Application number: 2021/90800	
What is the application for?:	Redevelopment and change of use of former mill site to form 19 residential units
Address of the site or building:	Hinchliffe Mill, Water Street, Holmbridge, Holmfirth, HD9 2NX
Postcode:

Type of comment: An objection	
Do you wish your comments to be published on the website anonymously?	Yes
<p>1) Over intensification of the site (too many houses) Although the number of houses has been reduced from 24 to 19, 19 dwellings is the indicative maximum capacity allocated for the development site HS190 in the Kirklees Local Plan 2019. (The Local Plan does not identify the size of dwellings so if 19 one-bedroom properties were developed the volume of cars would be considerably less than the 19 three/four-bedroom properties being proposed). If the developer wants to create large size properties, the number should be reduced from 19. The volume of traffic generated from proposed plans will be too high for the surrounding road network leading to an unacceptable impact on highway safety.</p> <p>2) Highway safety. Unacceptable impact on highway safety and severe impact to surrounding road network. Significant danger to the local commu

HOUSE TYPE : UNIT 2

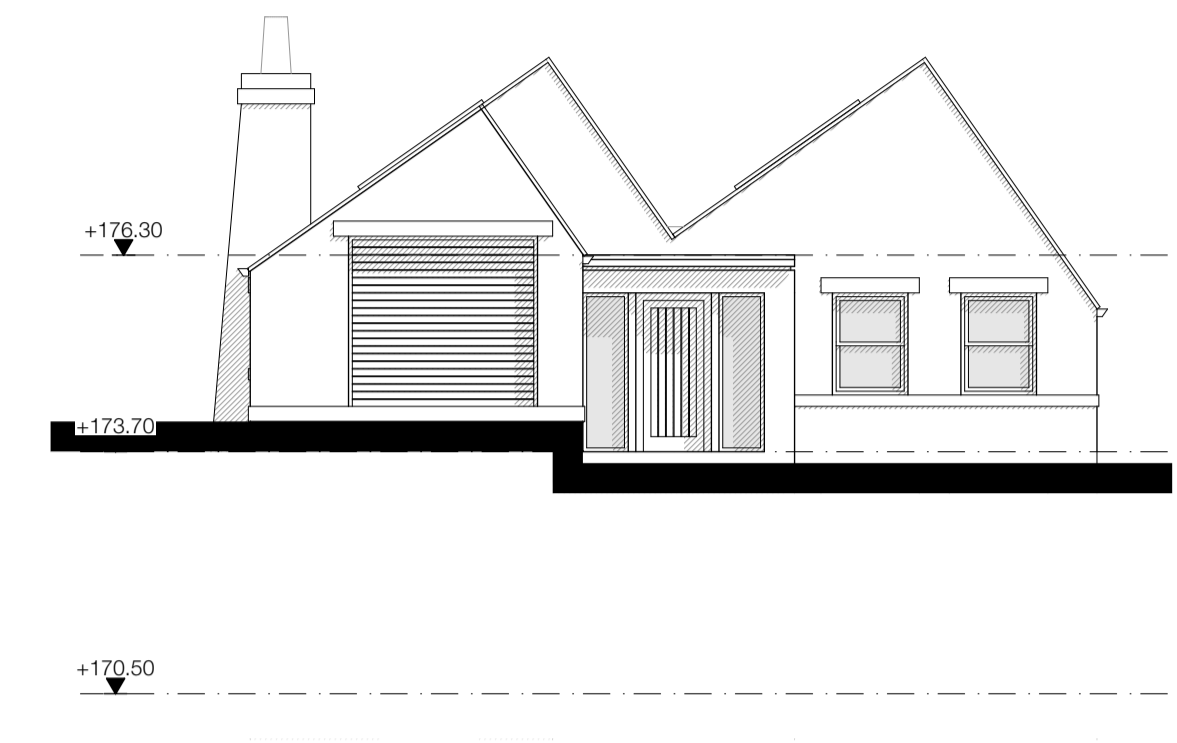
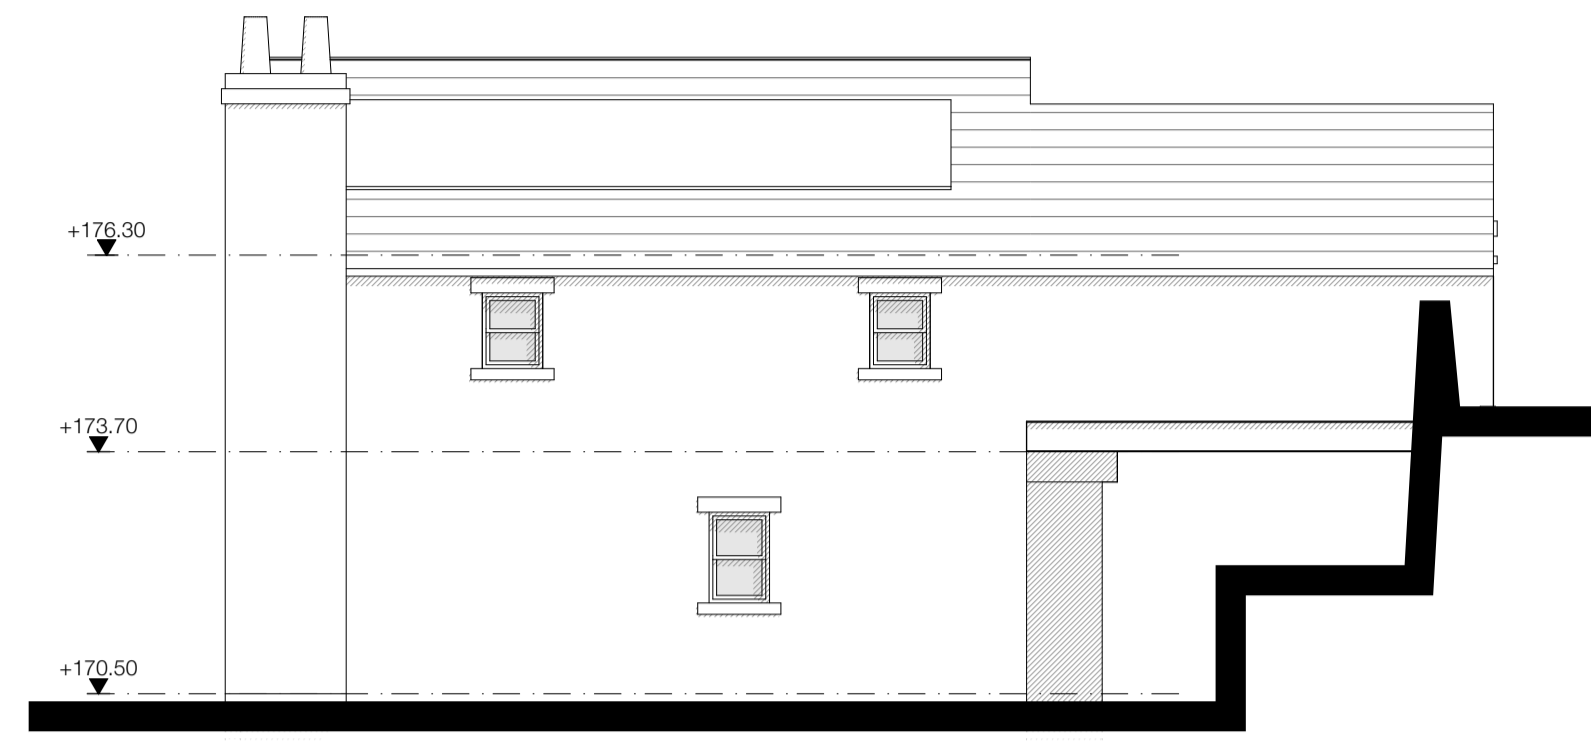
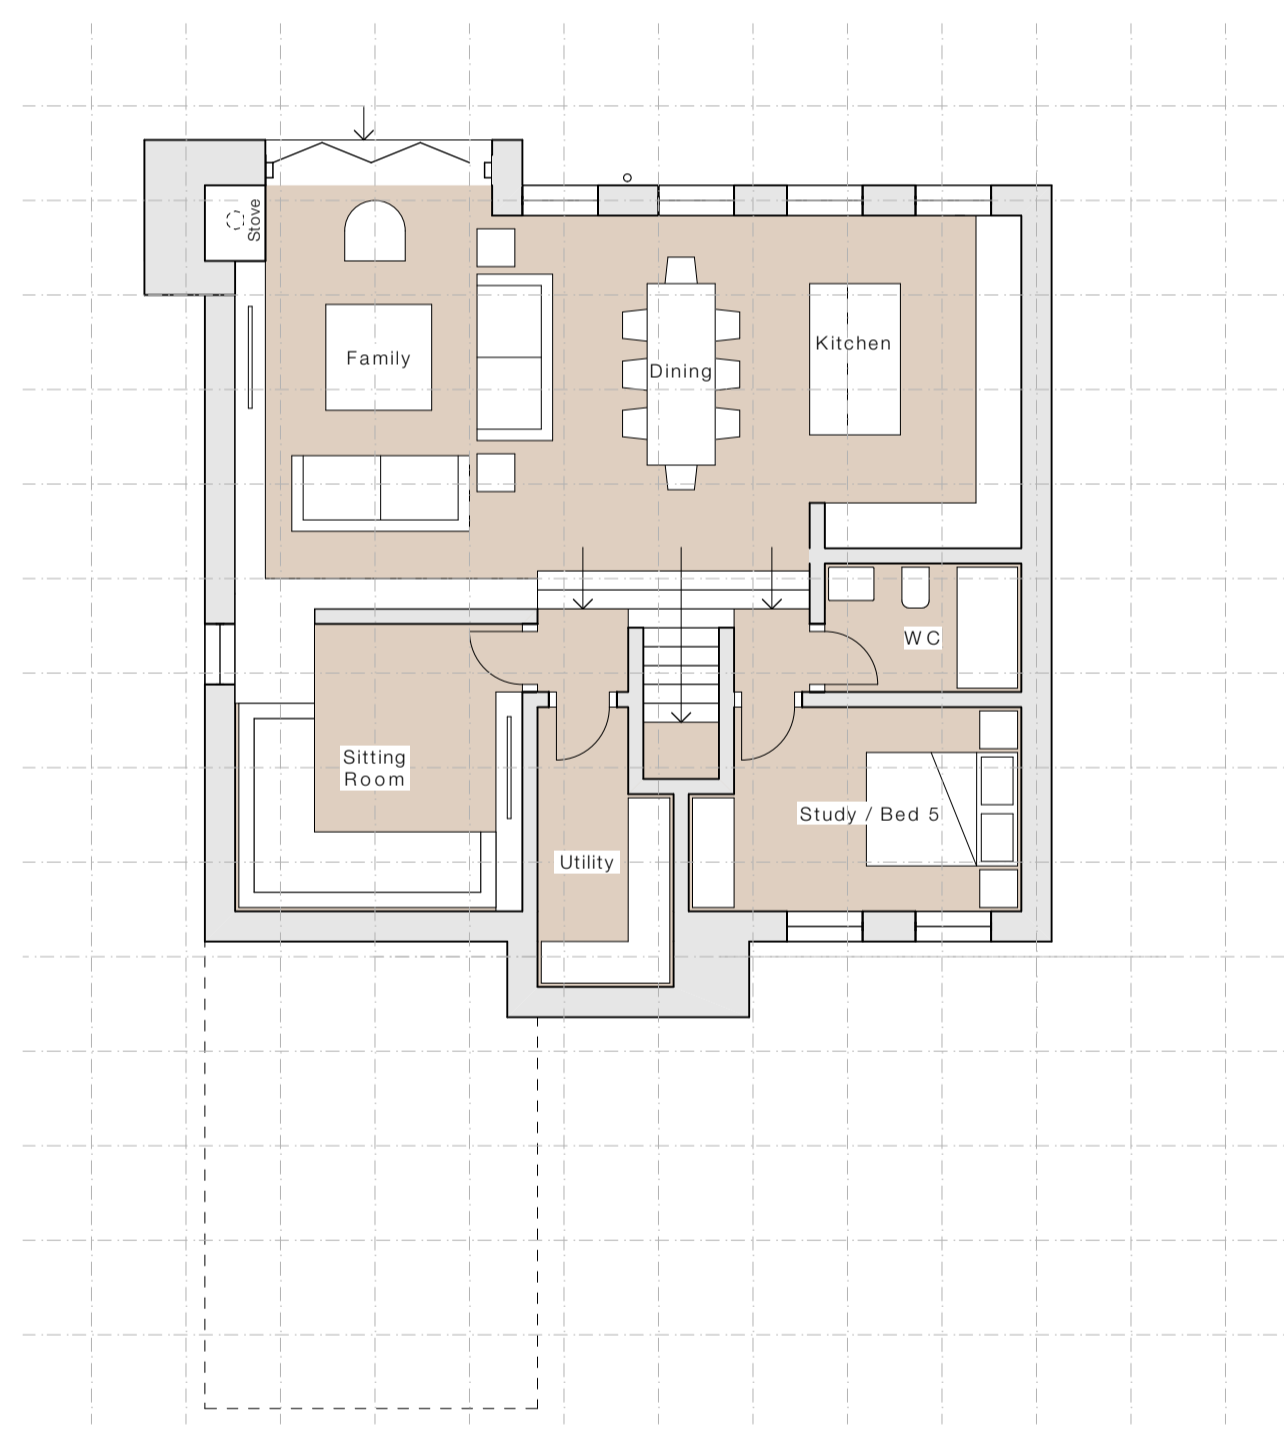
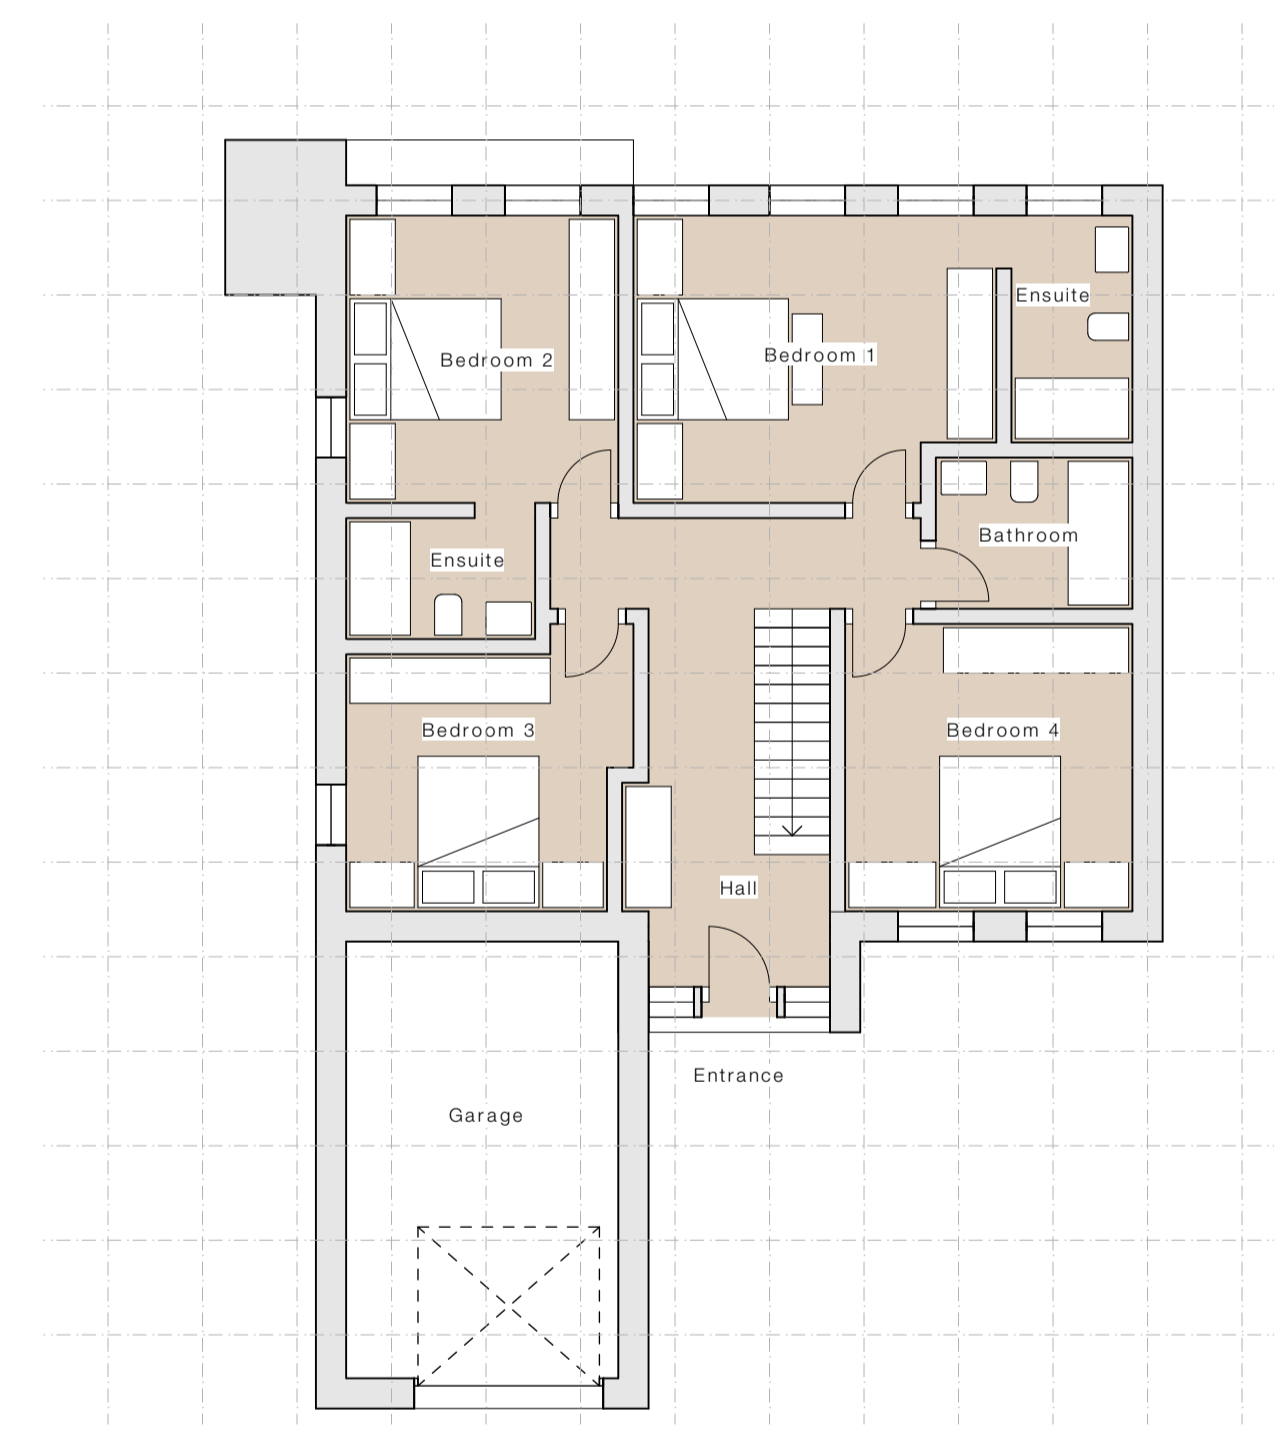
4) Scale and Massing (size). The scale and massing of plot 1 & 2 directly adjacent to the mill building, overlooking the dam are unduly dominant and out of scale with the heritage Class 3 asset mill building which would lose its local prominence, adversely affecting its village-scape merit and immediate setting. Historic England submitted concerns that previous plans presented a 'domestic' feel, at odds with the industrial character of the site which would not preserve or enhance the special interest of surrounding designated and non-designated assets and would be harmful to the character and appearance of the conservation area, and consequently cannot be supported. Complete removal of plot 1, or further reduction in scale and massing of plot 1 & 2 is required. Further design consideration is needed in keeping with the context of the industrial setting and surrounding properties in this conservation area.
